APPENDIX B: HUNTER INDOOR SPORTS CENTRE AGENCY ADVICE RESPONSE

5-11

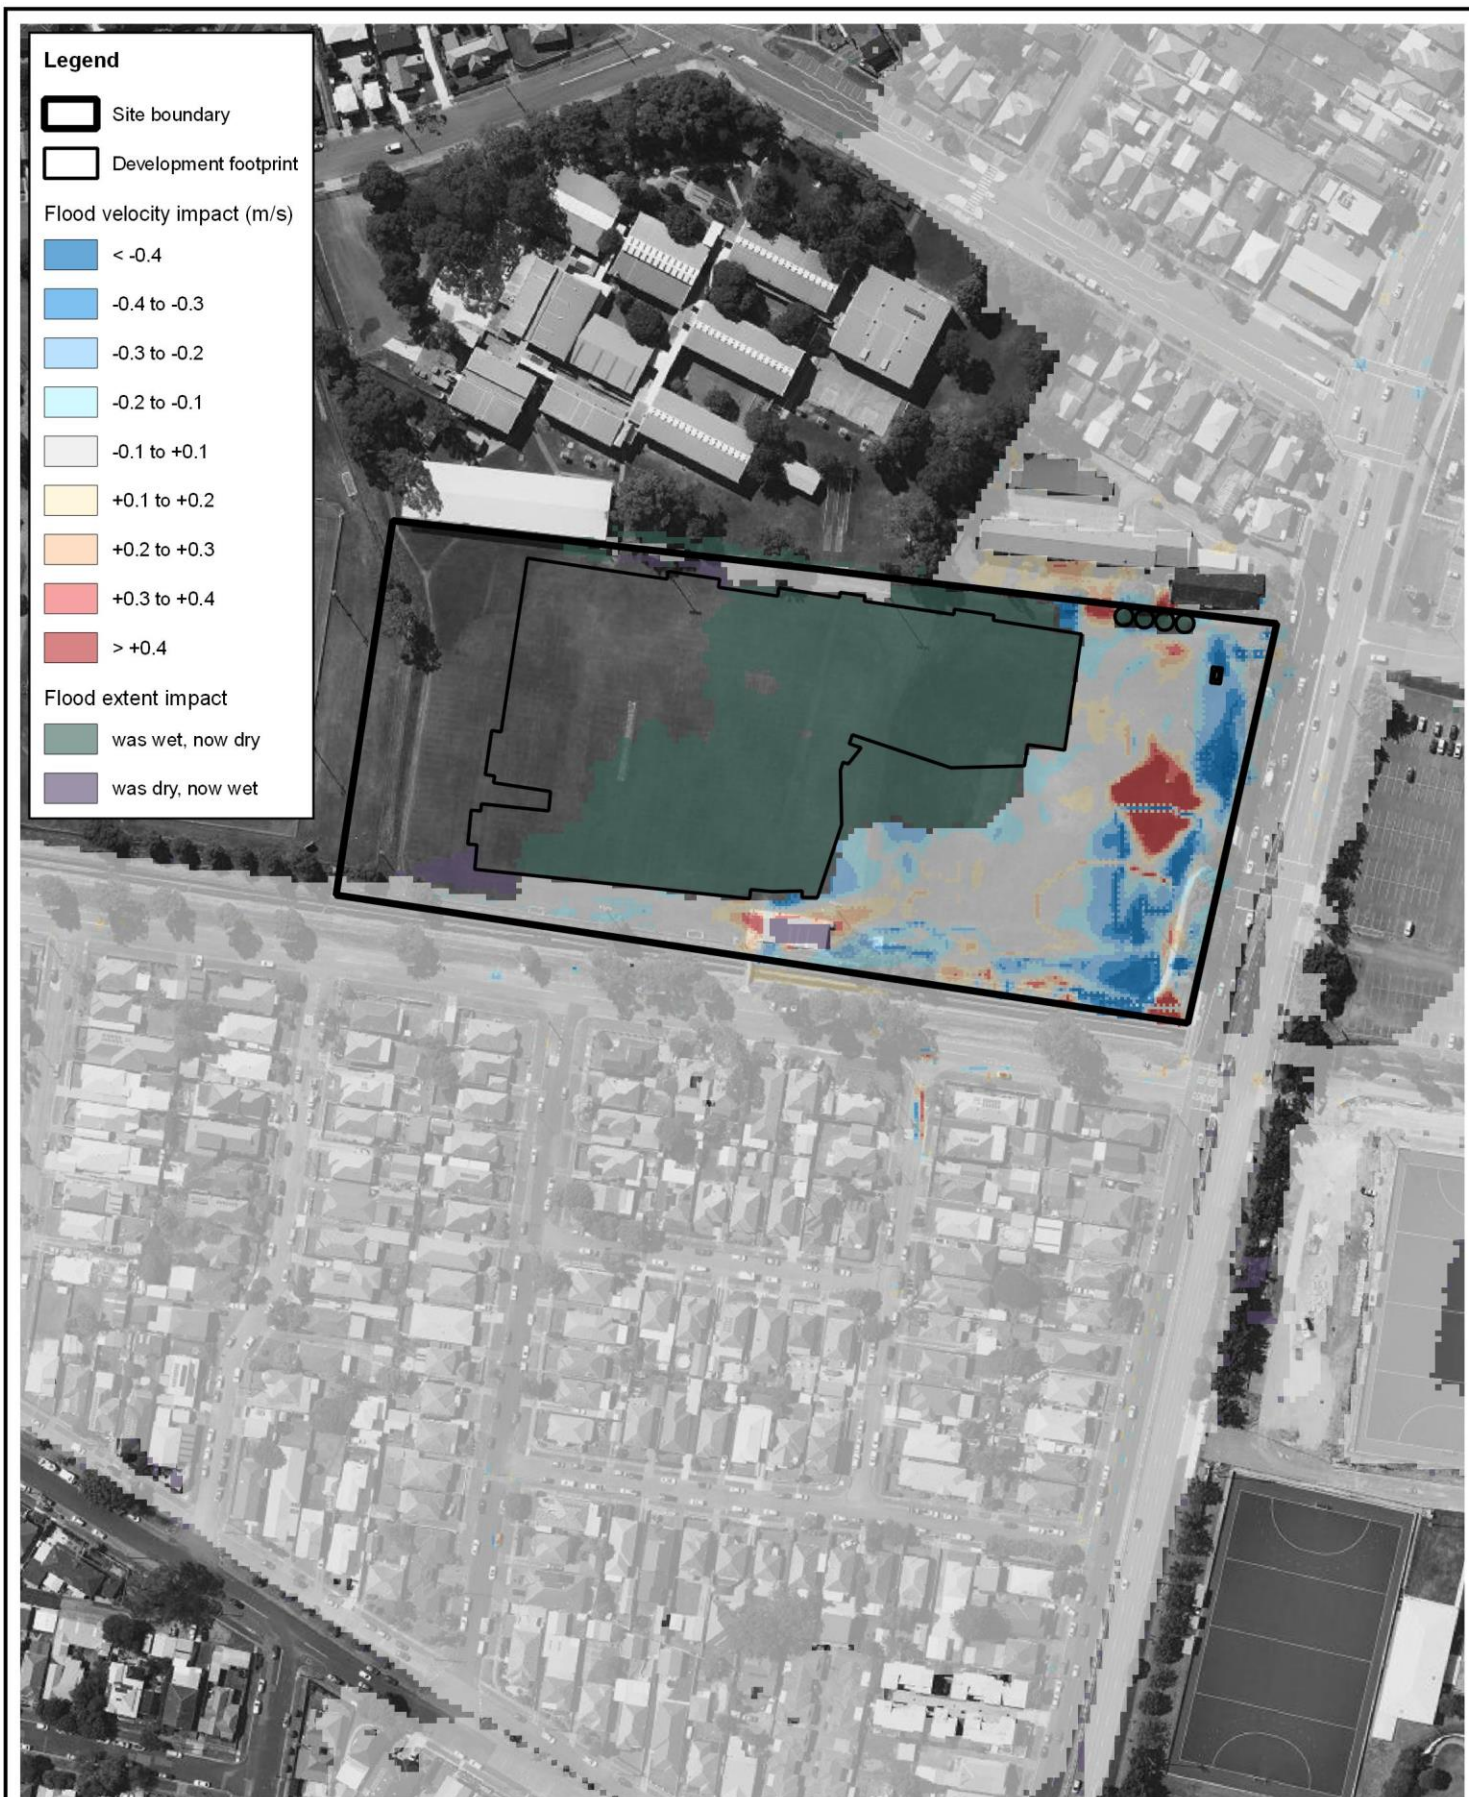
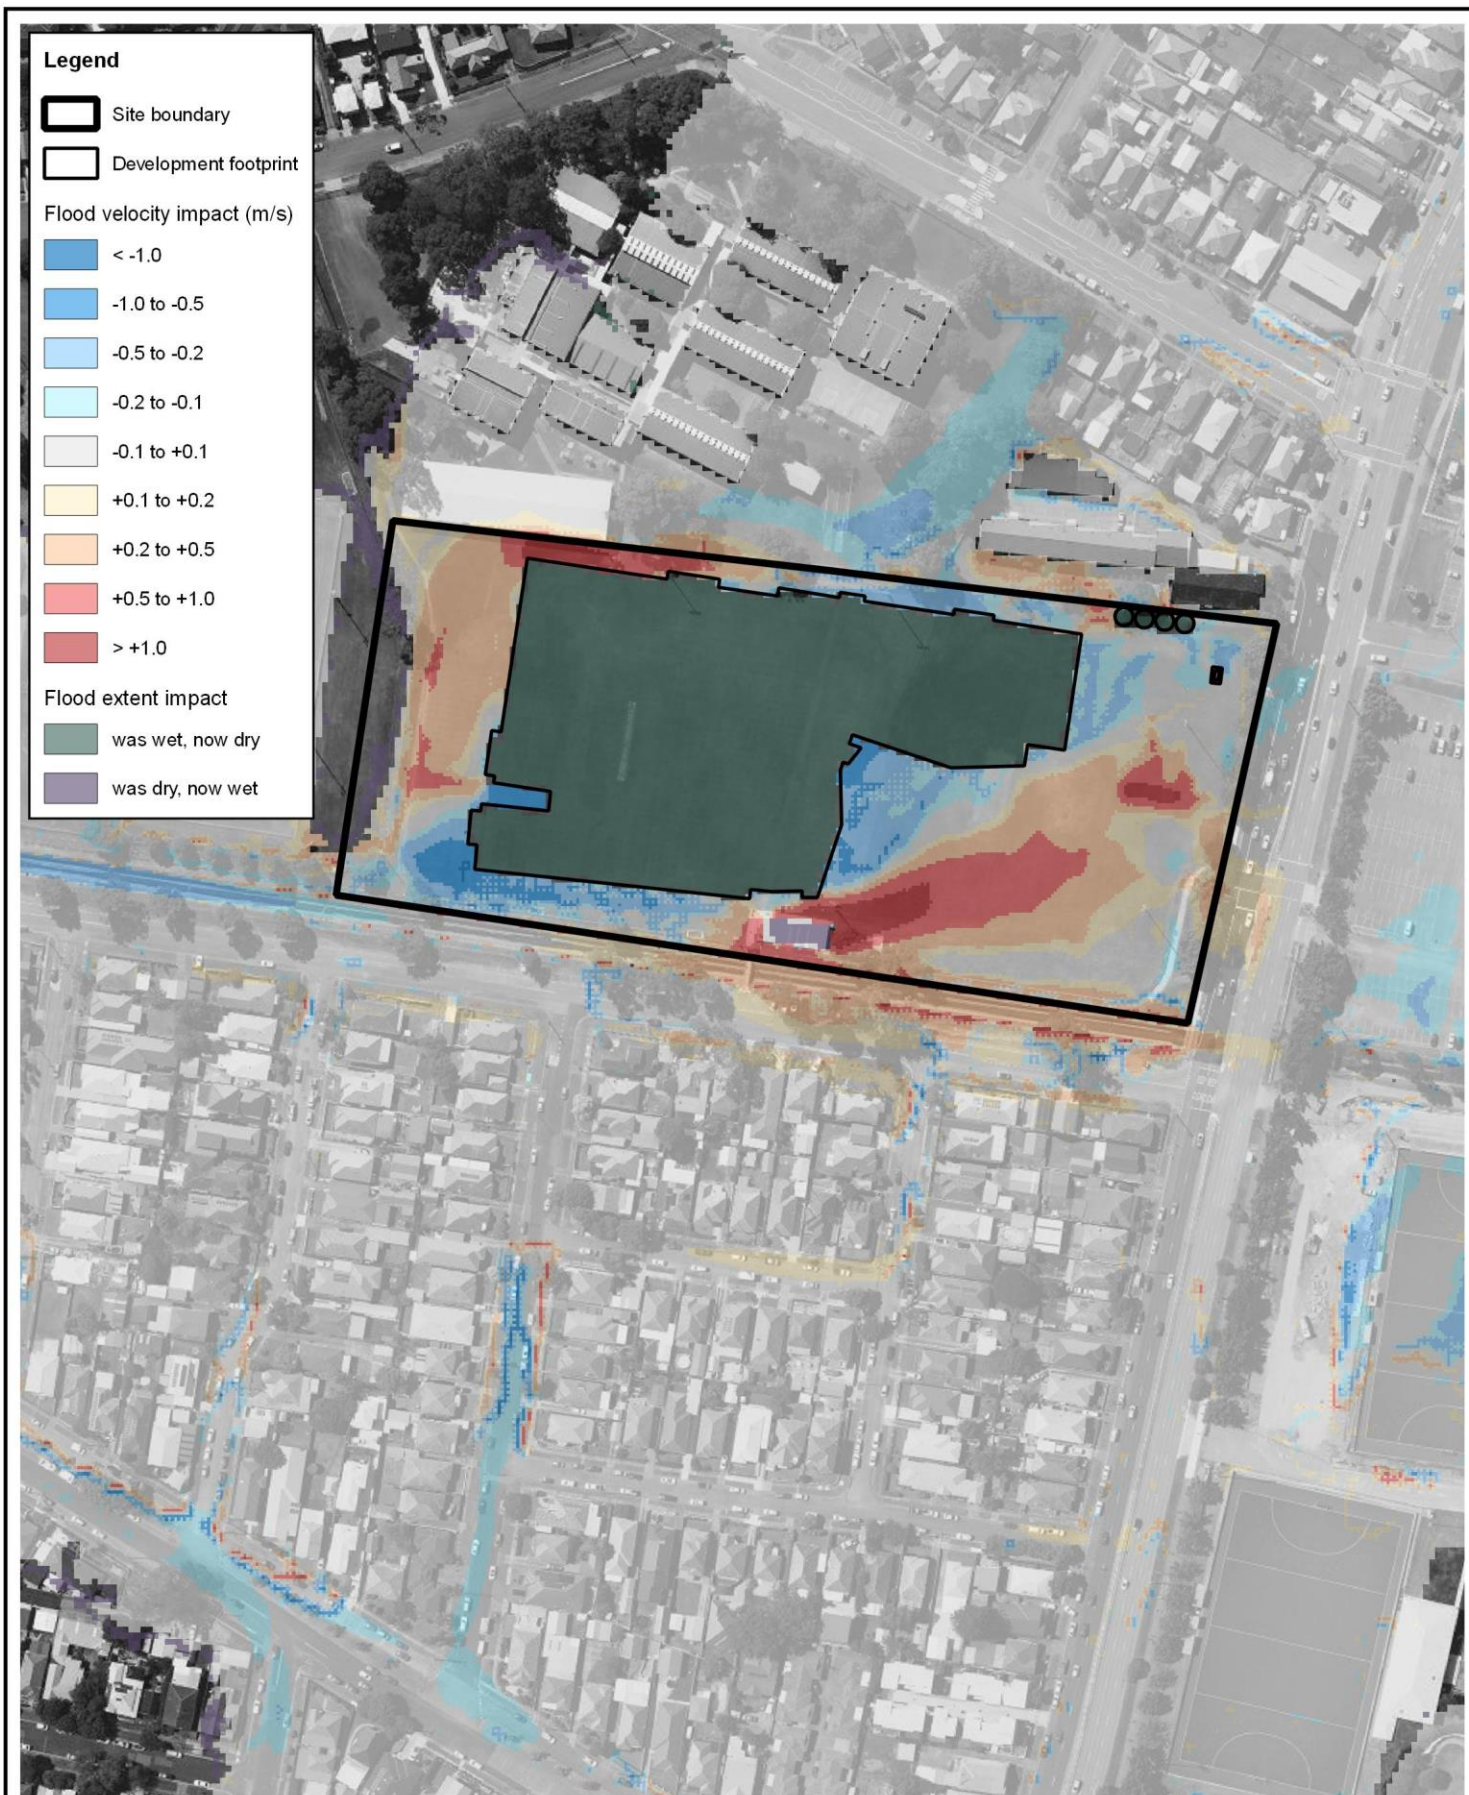
<p>(b)Mapping pre- and post-development peak flood velocities - Figures 5-11 to 5-13 in the FIRA highlight development impacts on flood velocities during the modelled events but no mapping was provided for velocities in the pre- and post-development scenarios.</p> <p>CN recommends that additional mapping is prepared illustrating pre- and post-development peak flood velocities for all modelled flood events to better inform how the proposal may change flooding in the area.</p>	<p>These additional mapping series are included at Appendix C of the updated FIRA- Appendix I.</p>
	<p>(c) PMF peak flood level impacts - CN does not support the proposed impact on peak flood levels during the PMF event at the scale and magnitude indicated in Figure 5-10 of the FIRA. The Newcastle Development Control Plan (NDCP) 2023 Section B1(b) Flood Management manages development in areas of high risk to life flooding through the requirement of on-site flood refuges at or above the PMF level and constructed to withstand peak hydraulic loading during the PMF. Increases to peak velocities and/or peak flood levels can undermine the effectiveness of any existing flood refuges. For</p>	<p>The updated flood modelling for the amended project shows off-site peak flood level impacts have been reduced, and are only +60-70 mm at the PMF event, which only just exceeds the +50 mm threshold and is well within the +100 mm threshold. Refer Section 5.3 of Appendix I.</p>

<p>(d)Peak flood velocity impacts - Figures 5-11 to 5-13 of the FIRA present modelled numerical impacts on peak flood velocities (i.e. in terms of m/s). CN recommends additional mapping is provided presenting the impacts of the development on peak flood velocities as a percentage increase/decrease from modelled pre-development velocities to allow assessment of these impacts against starting-point limits set out in Department of Planning and Environment's publication 'Flood Risk Management Manual'(2023).</p>	<p>These additional mapping series are included at Appendix C of the updated FIRA- Appendix I.</p>
	<p>(e)Proposed car parking in high flood hazard areas - Figures 5-5 and 5-6 of the FIRA indicate peak flood hazards in post-development conditions for the 10% AEP and 1% AEP 2050 flood events, respectively. CN notes the carparking areas of stages 1B and 2 and parts of 1A are affected by flooding at a hazard level of H2 and H3 during these events. In accordance with Control 8.0(C-7), CN does not generally consider carparking facilities to be suitable in areas subject to flood hazards greater than H1. It is also noted that at the modelled 10% AEP event, a high number of car parking spaces are affected by H3 and H2 flood hazards. Considering the intermediate frequency of the 10% AEP, CN is concerned the parking of vehicles in these areas will result in flood risks to property (including private vehicles). The proposed car parking areas in the front setback of the development (Stage 1B and Stage 2 car parking areas) are not compatible with the flood hazard of the land. CN recommends that the development be revised such that no car parking facilities are provided in these areas and these areas remain usable open space. In this regard, the Applicant may consider:</p>	<p>The assessment of the updated design is documented in the Flood Impact Assessment Report (FIRA)(Appendix I).These comments have been considered in the amendment to the site layout which set the building back from Turton Road and provide a grassed swale to enhance the function of the floodway. The level of the proposed car park has been raised to reduce the flood hazard exposure and it now complies with the requirement of the Newcastle DCP.</p>
